Your Ref: OWPC15382
Our Ref: AW/208/17/HH 16-07-2017
Please ask for:
Richard Temple

Single storey front extension as annex for elderly relative
31 Queens Fields West Aldwick

Block Plan 1:500

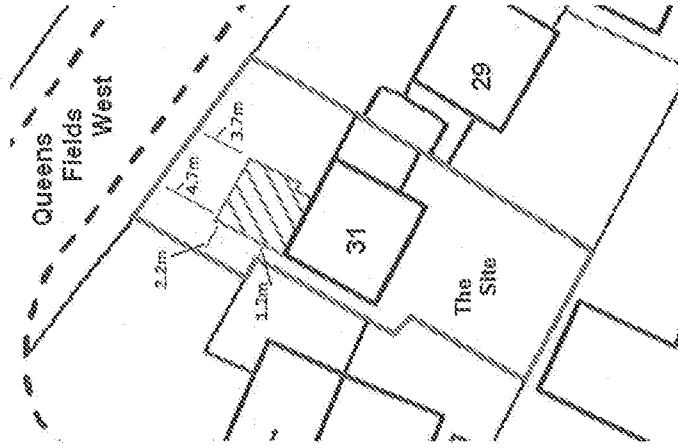
- 1. From the information supplied, it appears that the extension will have just two fanlight windows on the front of the extension. This will be unsightly and reminiscent of a public toilet.*
- 2. The proposed extension will be built way beyond the current building line and may block the afternoon sun from the front of properties to the east. This is unneighbourly.*
- 3. One of the documents "EXISTING AND PROPOSED BLOCK PLANS, EXISTING ELEVATIONS" cannot be viewed on your website.*
